REQUEST

Current Zoning: N1-B (Neighborhood 1-B)
Proposed Zoning: N2-A(CD) (Neighborhood 2-A, Conditional)

The petition proposes to develop a vacant, wooded property in the S Tryon Street corridor with a community of up to 50 multi-family attached dwellings.

The Drox Group, LLC

RZ-1.0

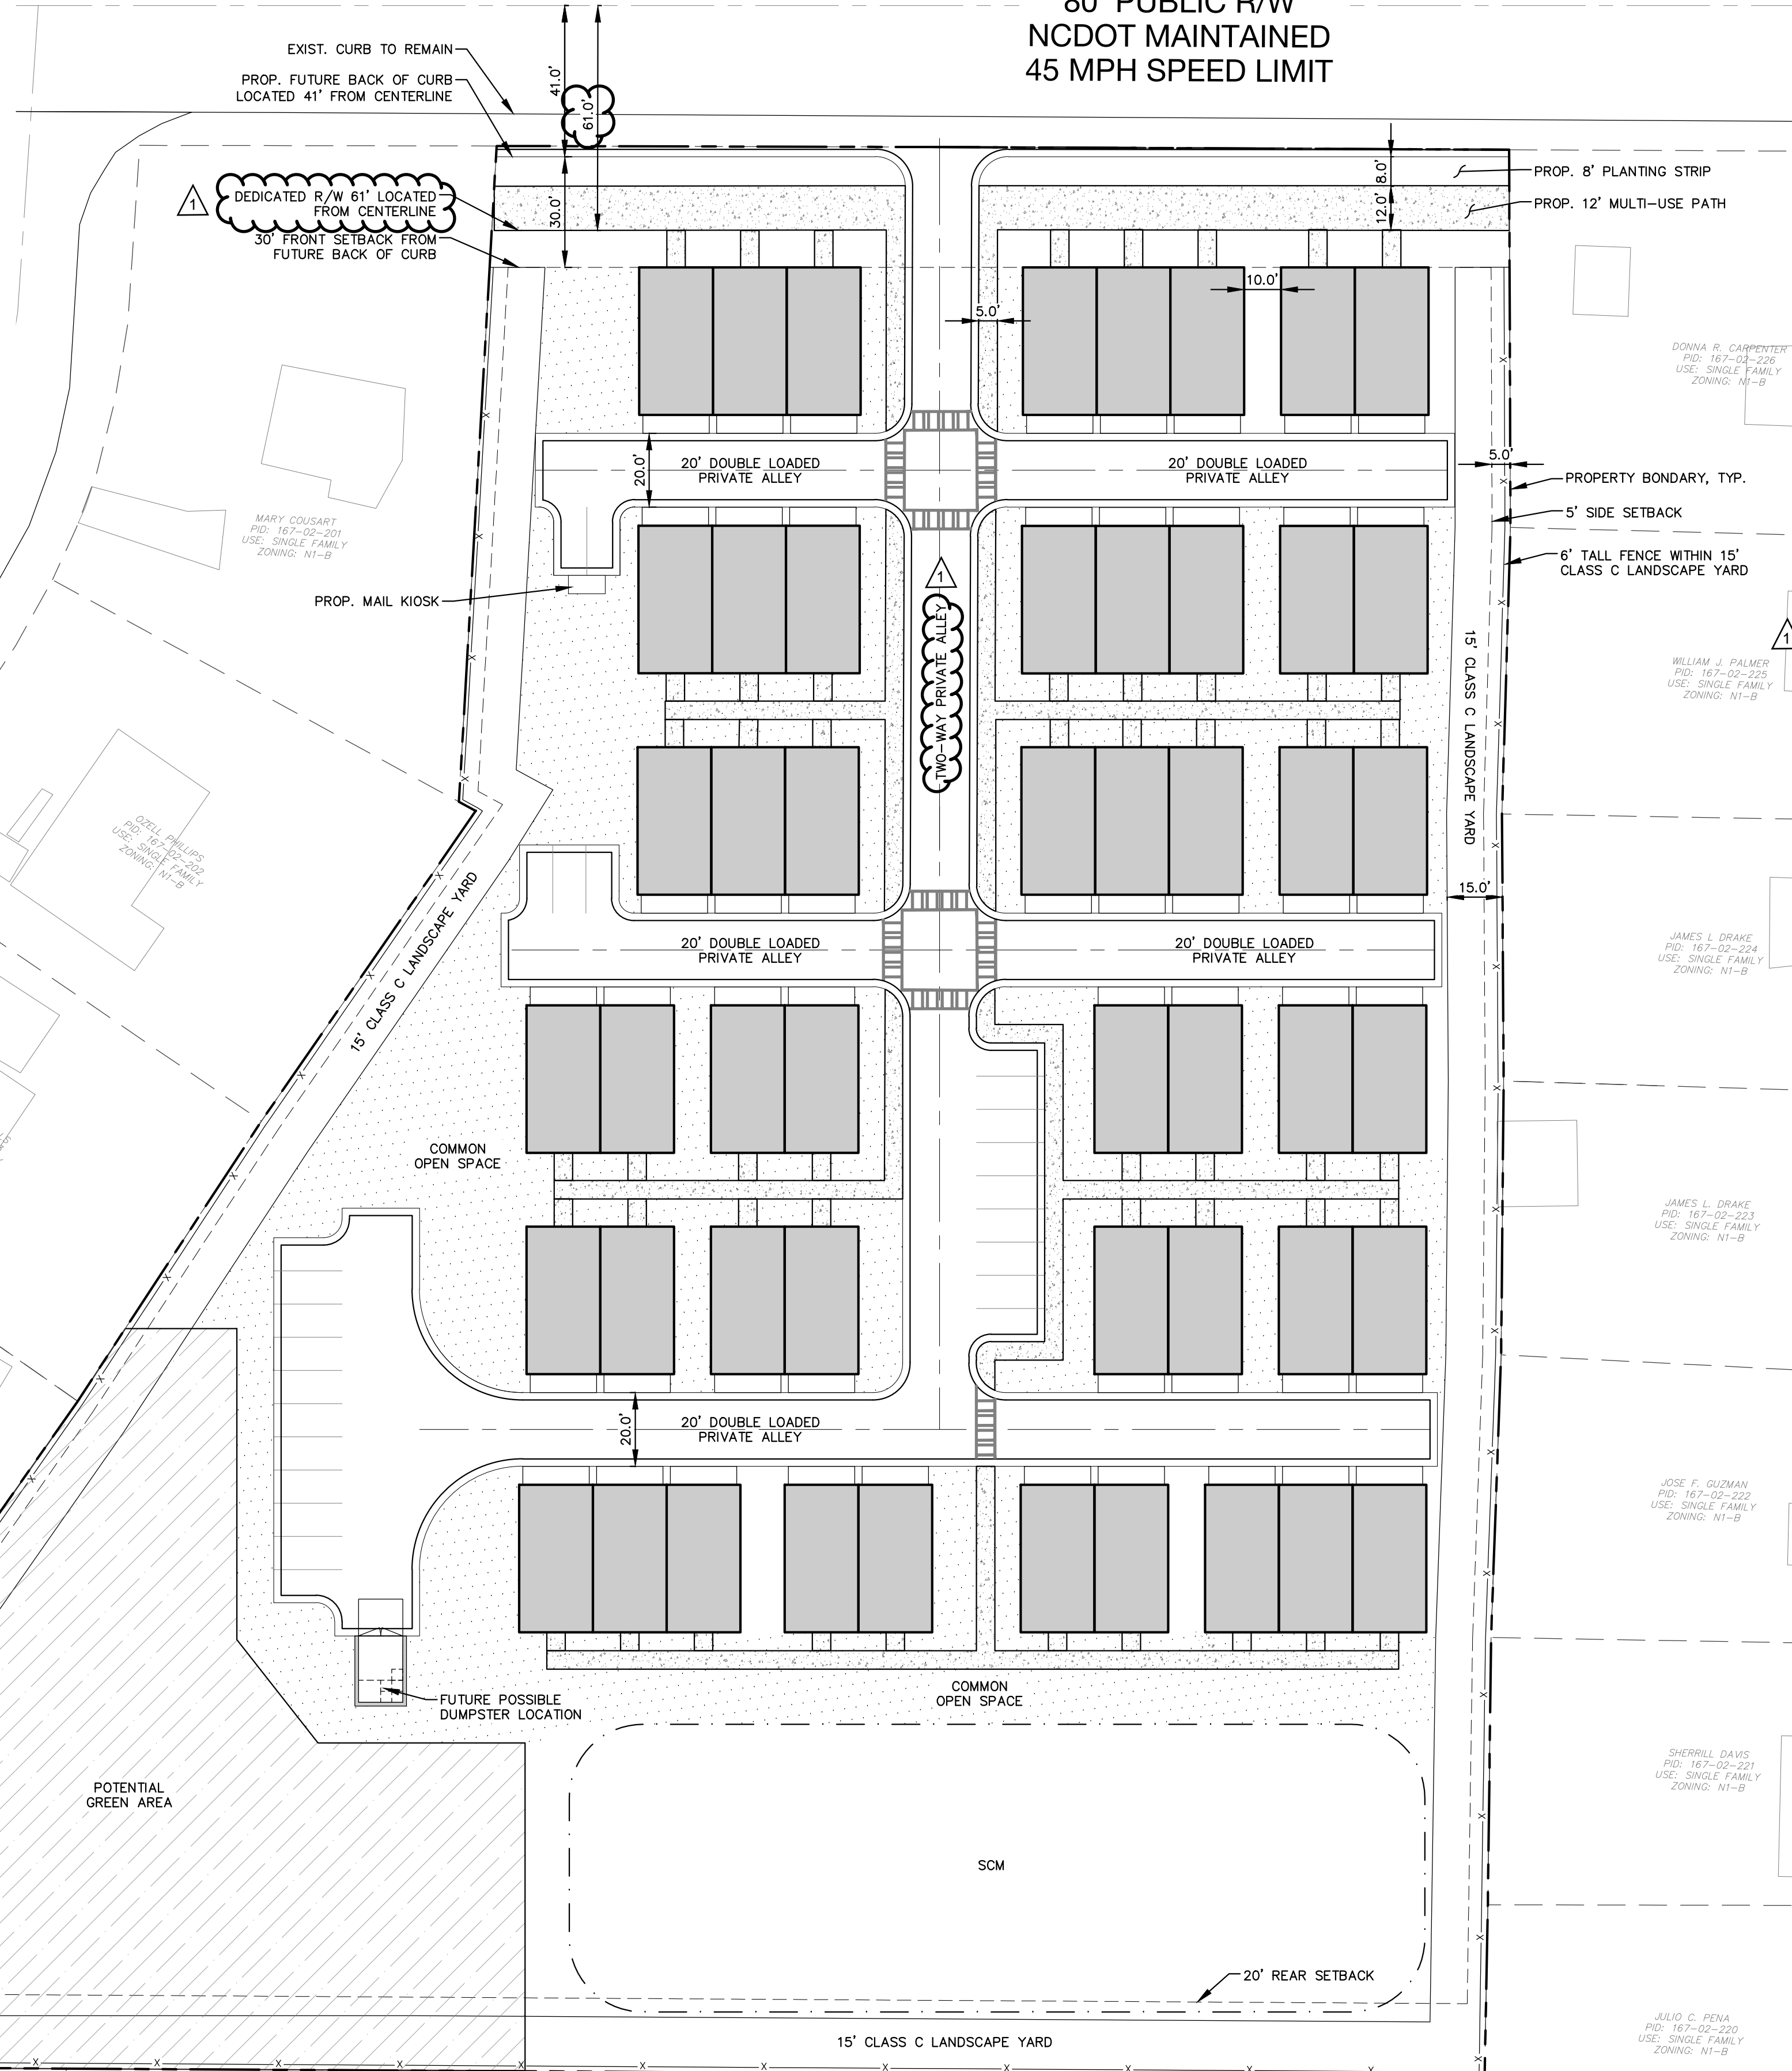
1. In coordination with NCDOT, revise site plan and conditional notes to install a right turn lane into the site with 50' of storage.
2. Use only one line to show future back of curb. Move the driveway cut and curb and gutter to the existing location.
